Date: 30 June 2021
Our ref: 358449
Your ref: BN/153/20/PL

Planning consultation: HRA & Appropriate Assessment - 44 No. dwellings & associated infrastructure. This site falls within the BEW Strategic Site, CIL Zone 1

Location: Warwick Nursery, Barnham Road, Eastergate, Barnham PO20 3RT

SUMMARY OF NATURAL ENGLAND'S ADVICE

PROPOSED PLAN
INDICATING TREE
PROTECTION MEASURES

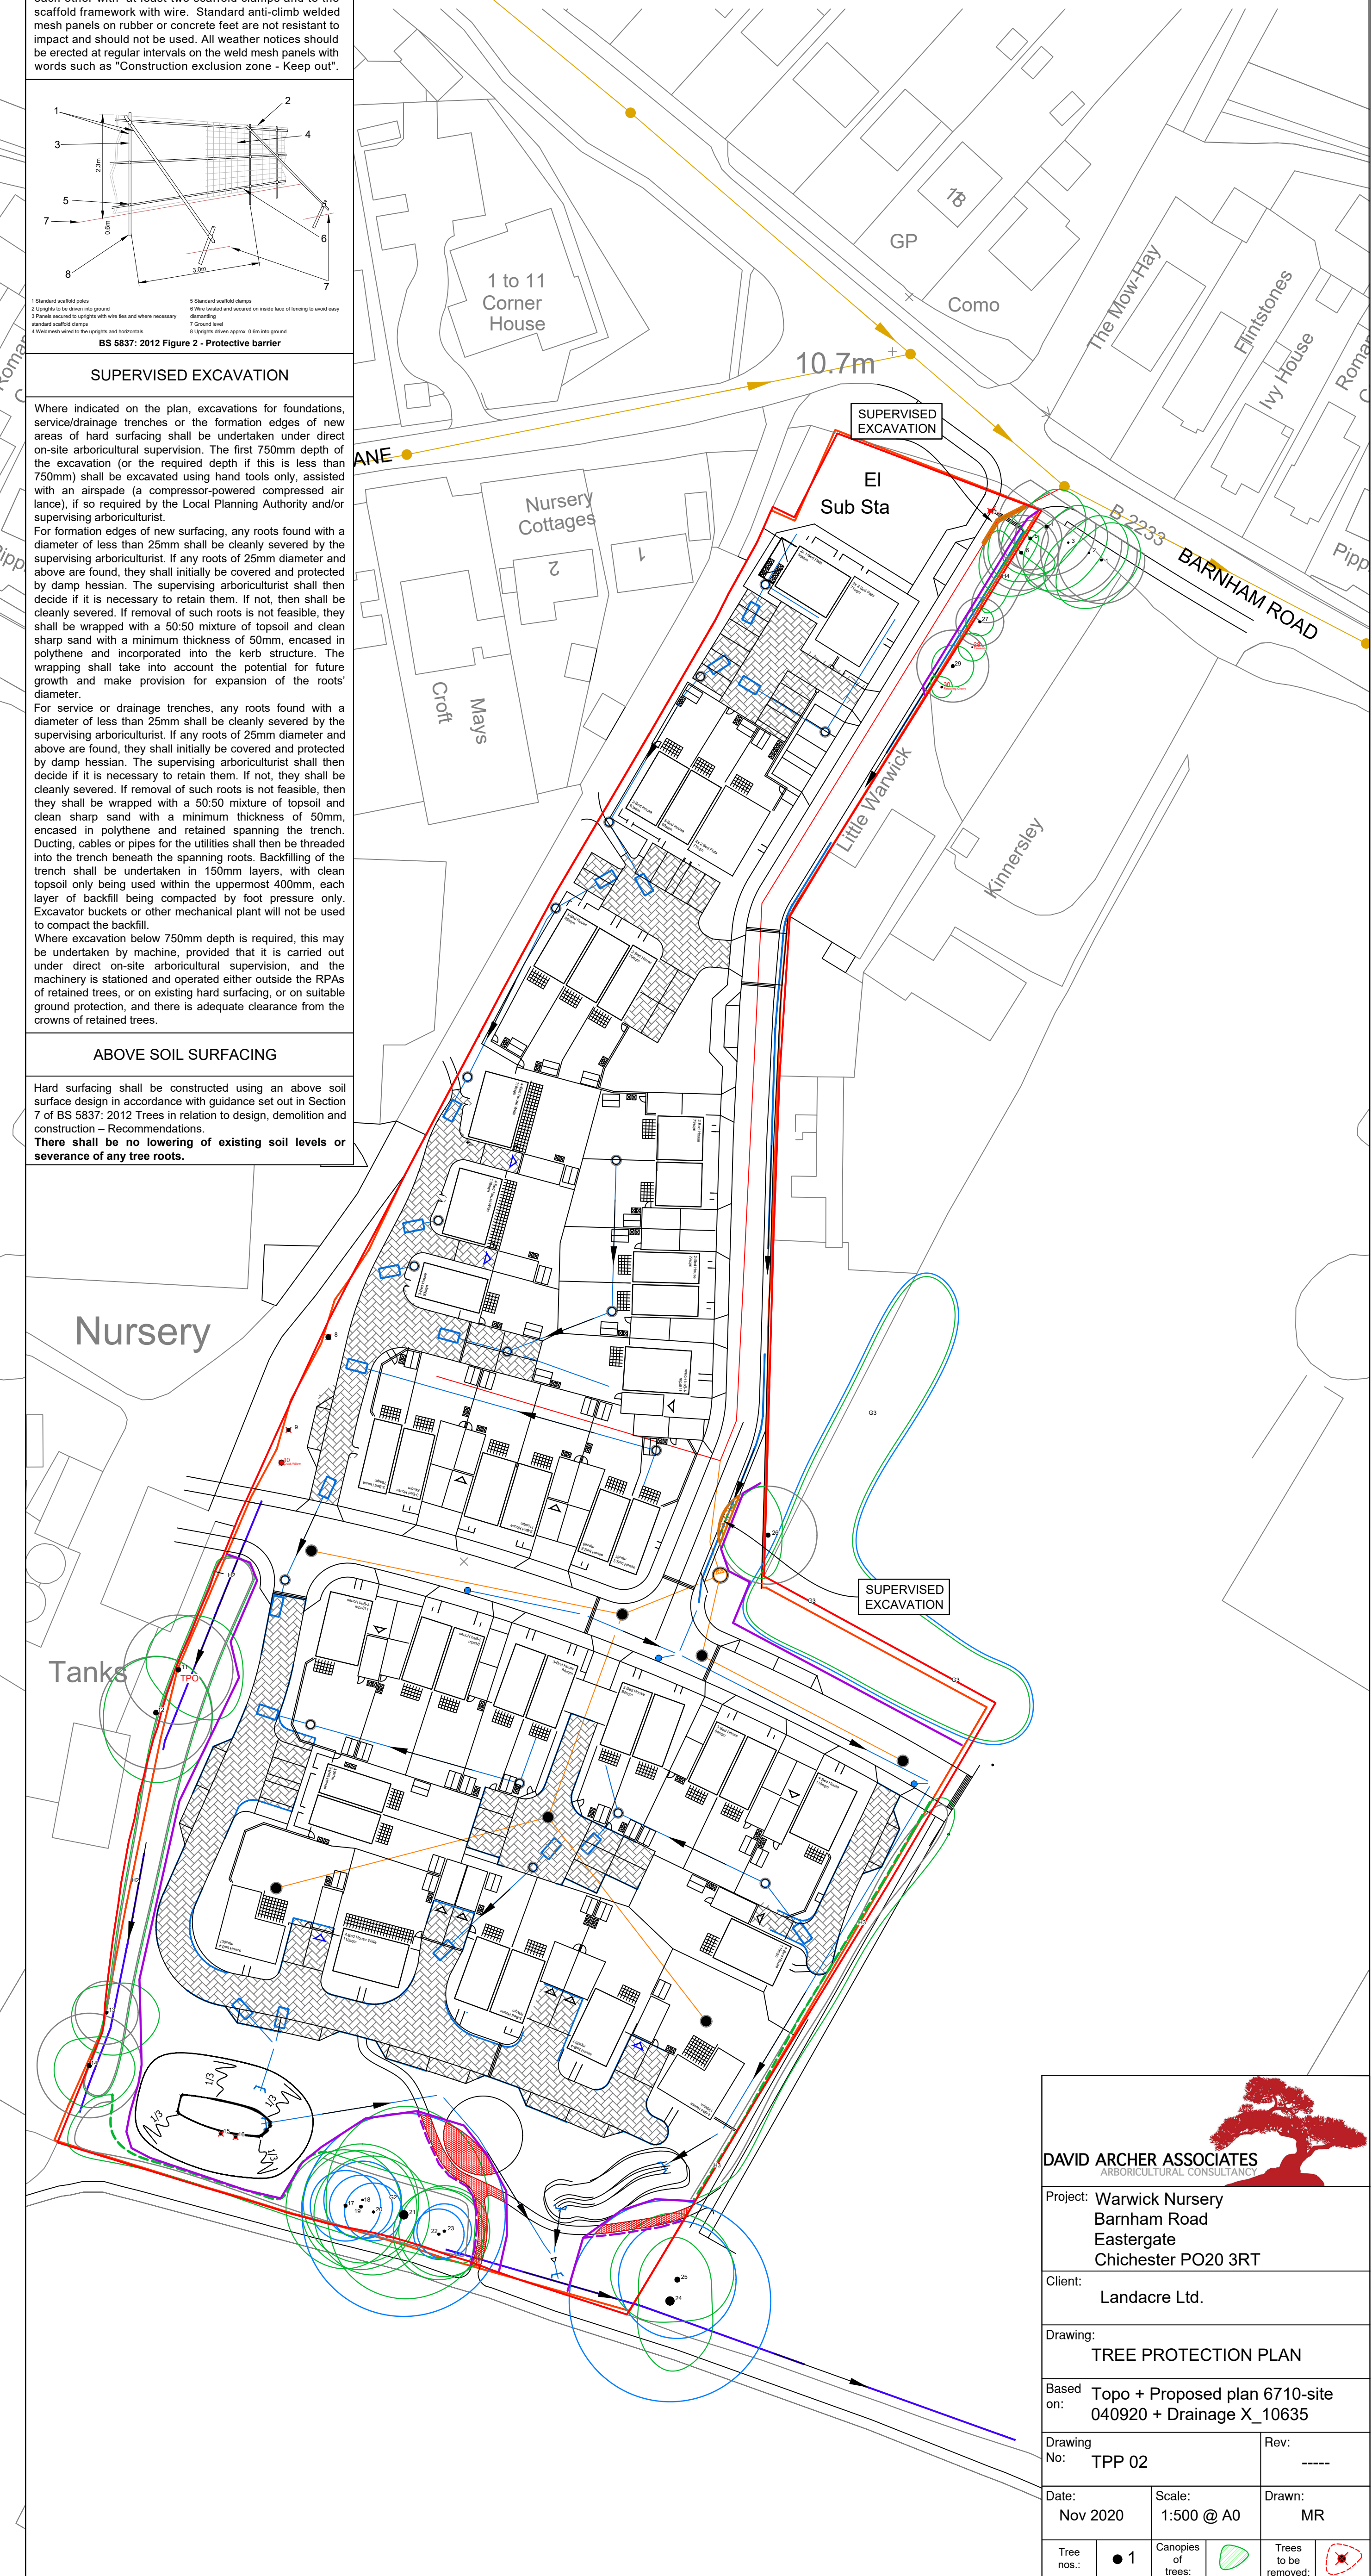
Natural England support the measures suggested to protect existing habitat features from damage, specifically the installation of secure buffers around such features during the construction phase. To prevent ambiguity in what measures need to be secured, we advise that it is specified which features will be protected by buffers.
